EL PASO COUNTY DEVELOPMENT SERVICES DEPARTMENT
SIGN APPLICATION

SC1821

Name: Van city RV
Address: 1426 Selix
Grove 80915

A FRONT ELEVATION
SCALE: 3/8" = 1'

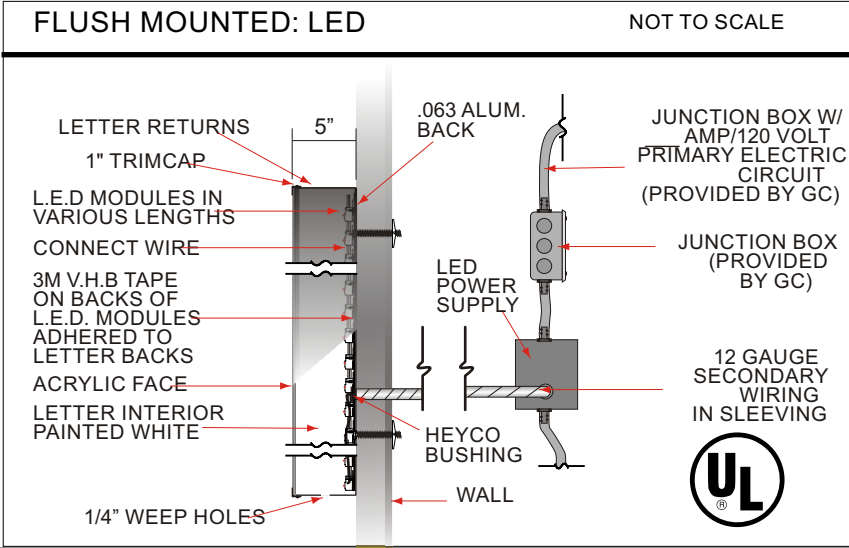
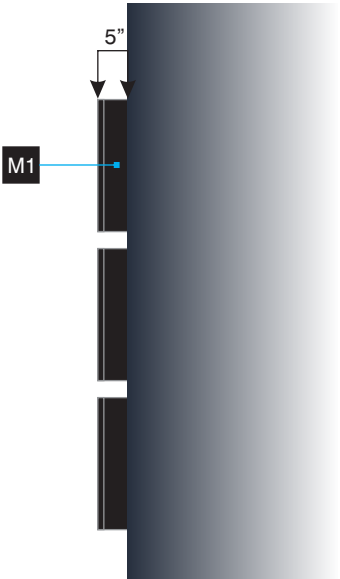
Sign must meet section 6.2.10.D.3.e.vii No sign shall be illuminated unless the source of light is steady and suitably shielded in accordance with lighting standards of the code.

CS zoning allows for 1.5 sqft per linear foot of building wall, or 300 square feet whichever is less.
